Ribble Valley Borough Council  
Development Control

Application no: 3/2020/1028

Address: Pillings Farm, Grindleton Road West Bradford

Proposal: Demolish and replace existing barn

LOCATION PLAN

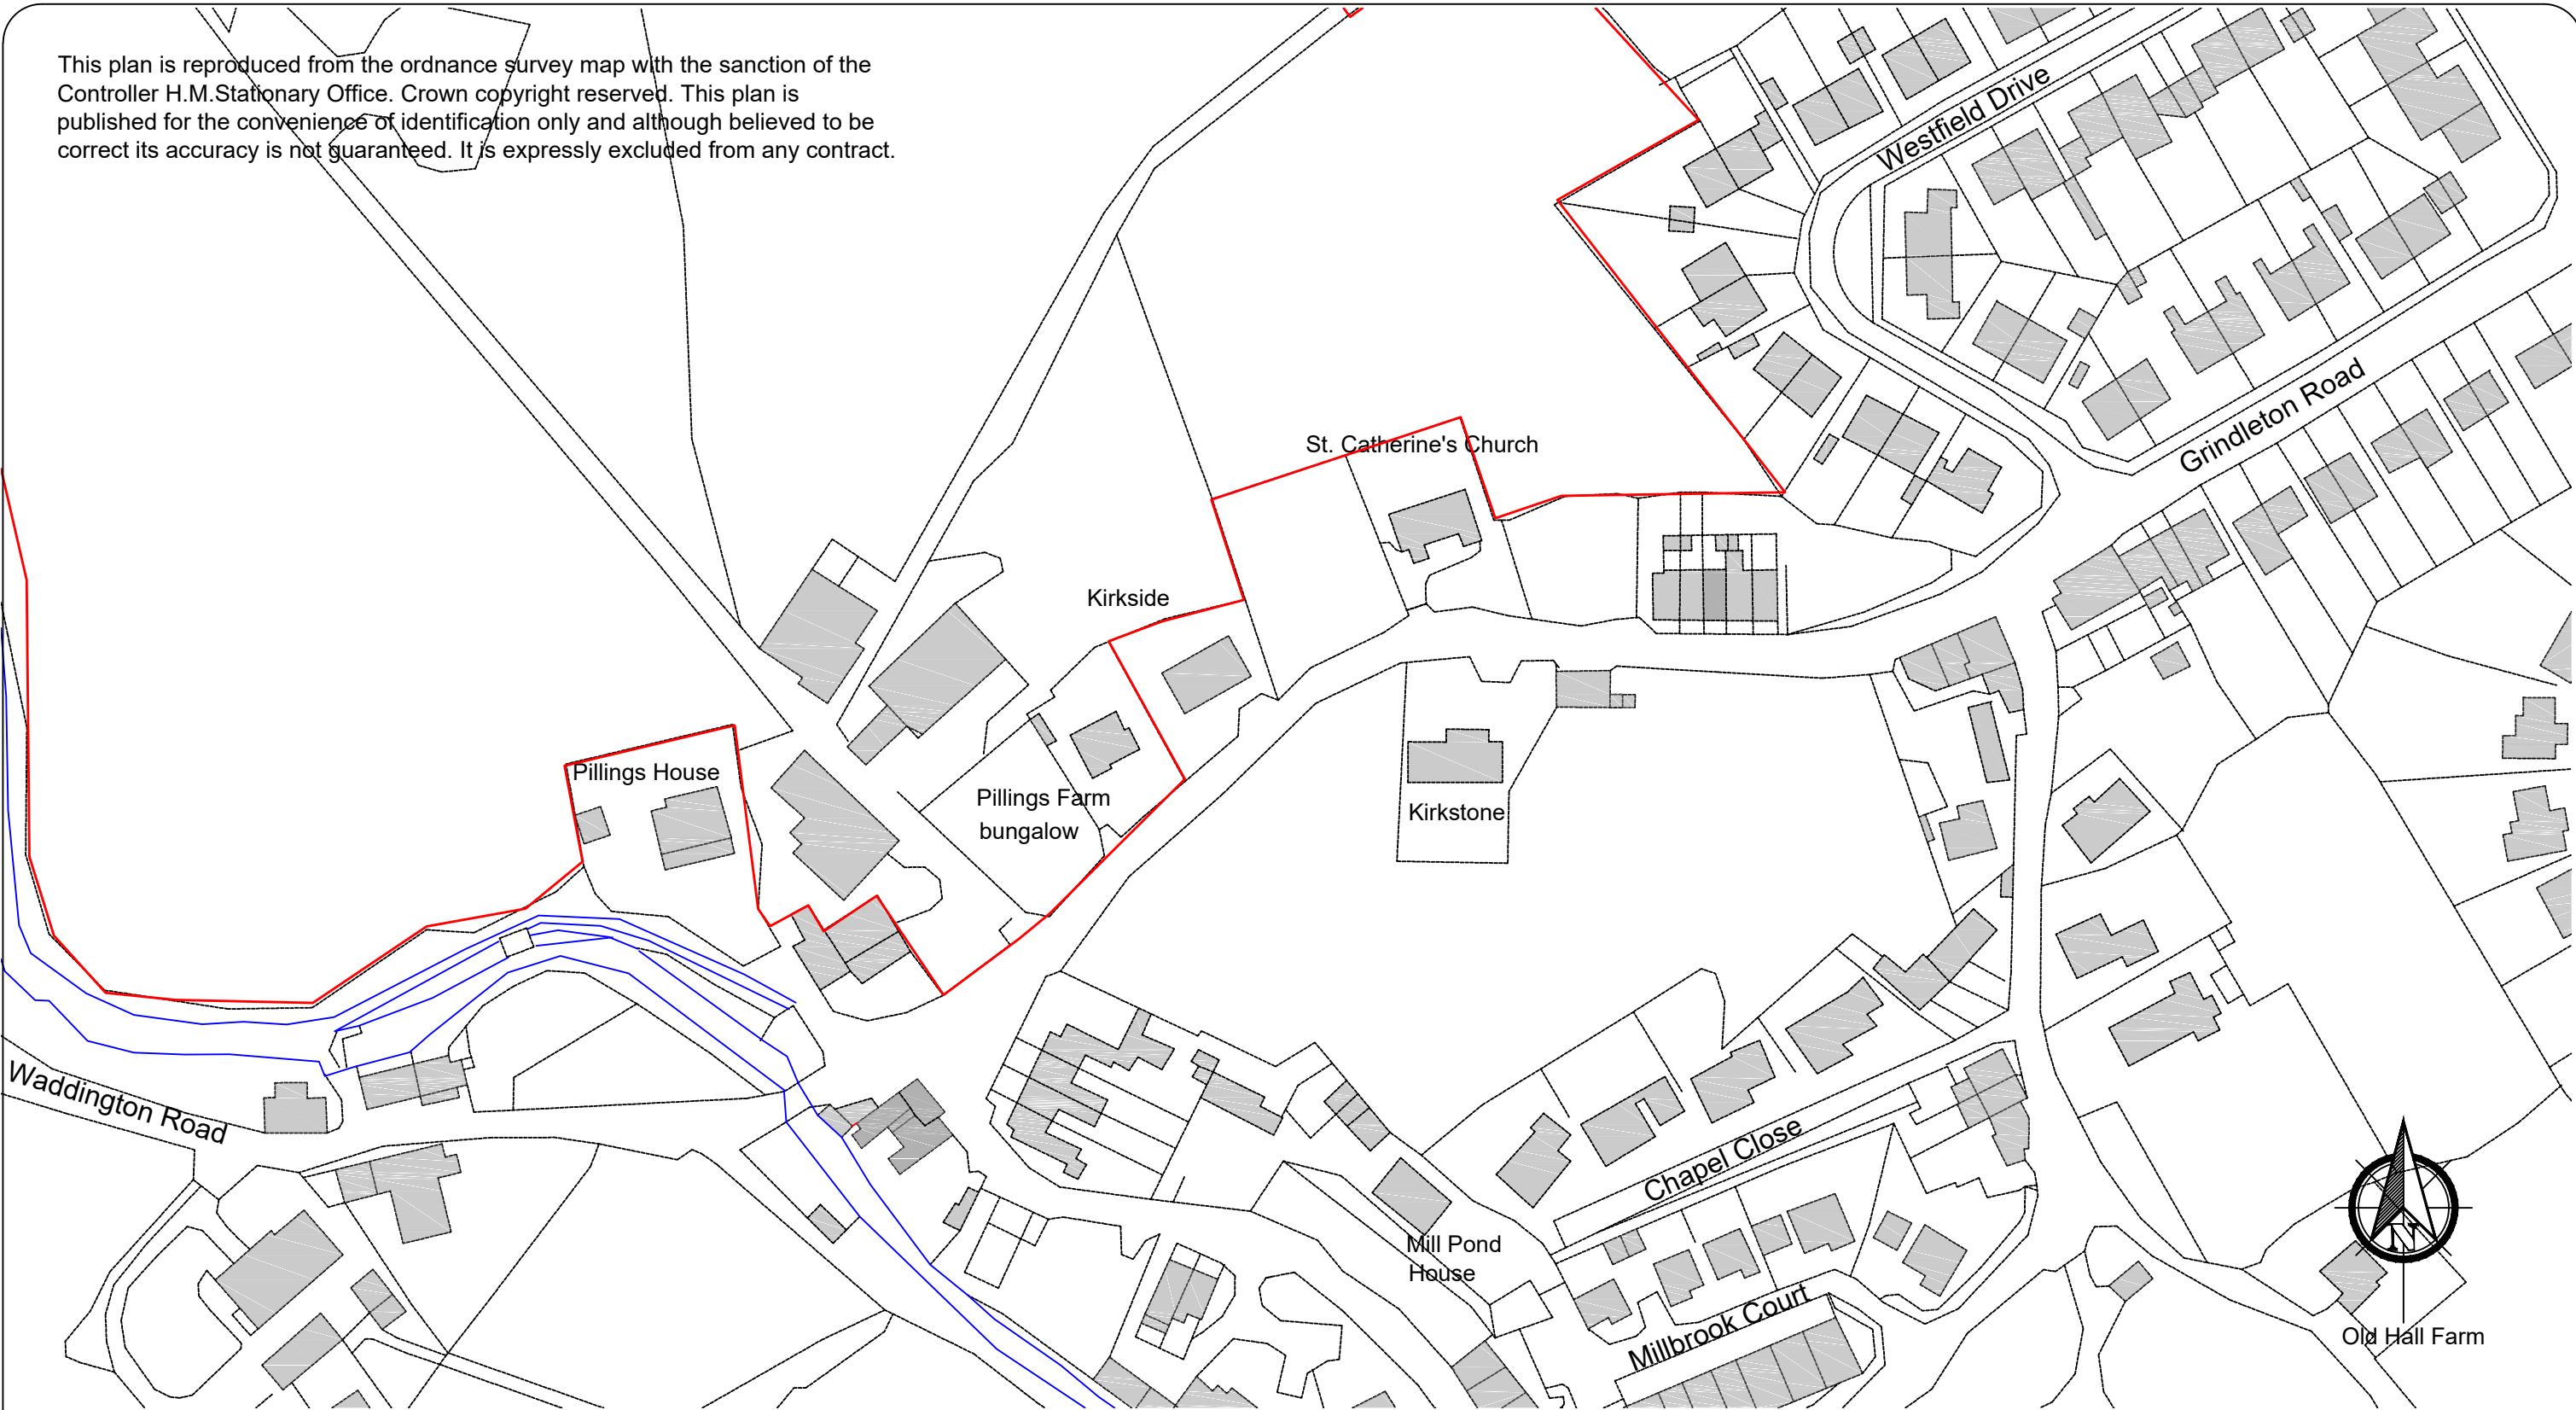
The proposal raises no highway concerns and I shall therefore raise no objection to the proposal on highway grounds, however the applicant has identified the need to diver public footpath 3-44-FP18. I assume that the County Council's PROW team have been consulted separately on this application a they will be aware of the legal processes to follow to divert the footpath.

No development of the approved scheme as submitted shall commence until such time as the necessary diversion of public footpath 3-44-FP18 has been formally diverted under the appropriate legal process in consultation with the local planning authority and the highway authority.
